**Washington State
Department of Transportation**

June 21, 2018

Subject: PF-18-00001 – Kittitas County Public Works
SR 903 & NO 5 Mine Rd. milepost 3.59 right

KITTITAS COUNTY
UPPER MAINTENANCE SHOP
SITE LAYOUT - CONCEPT D

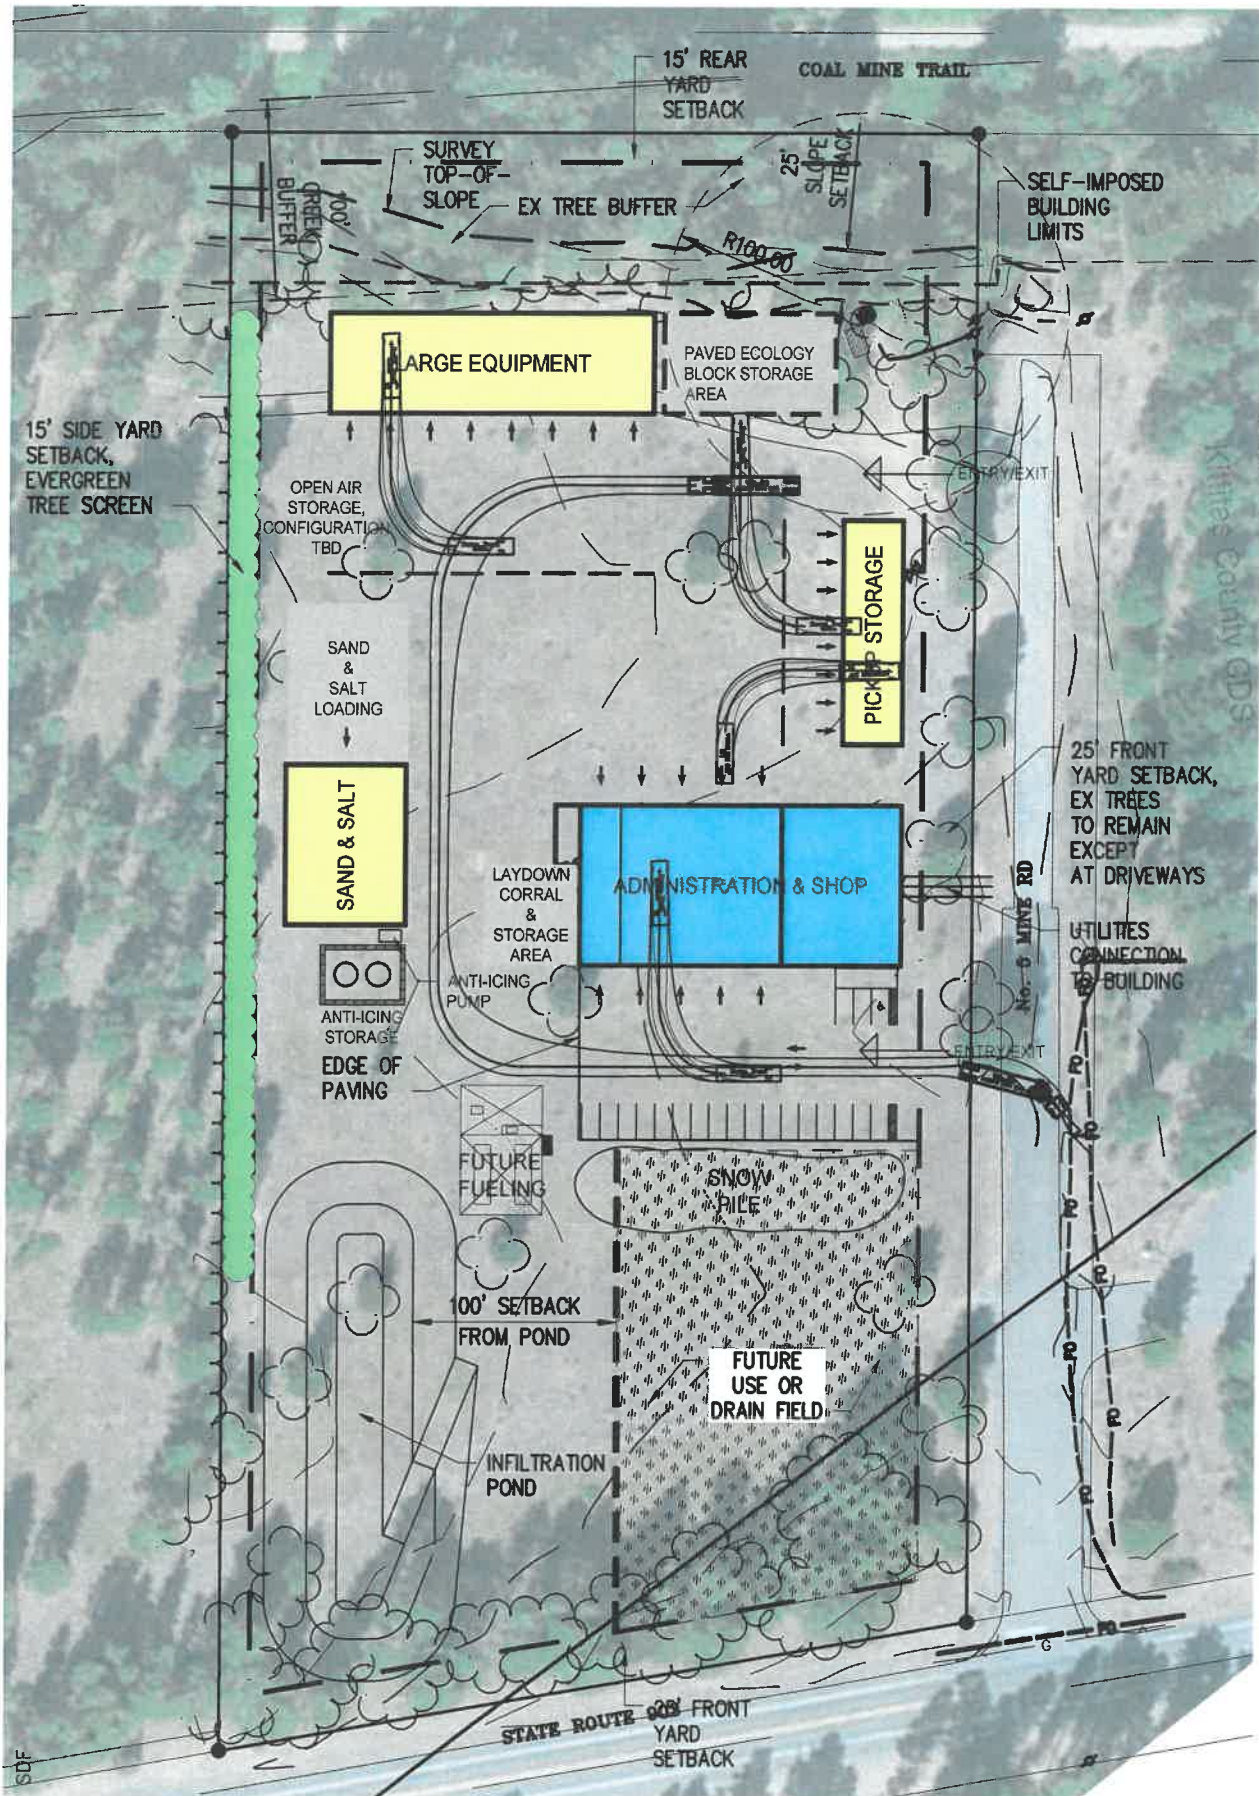
- The subject project is adjacent to State Route 903 (SR 903) and the County's NO 5 Mine Road. SR 903 is a Class 4 managed access highway with a posted speed limit of 45 miles per hour. Access to the proposed project will be from NO 5 Mine Road.
- Any utility that crosses WSDOT rights-of-way requires a crossing permit and open cutting of the highway requires a variance to WSDOT policy. The proponent is required to contact the South Central Region Utilities Engineer, Jamil Anabtawi, to coordinate this work and obtain the necessary permit(s). He can be reached at (509) 577-1785.
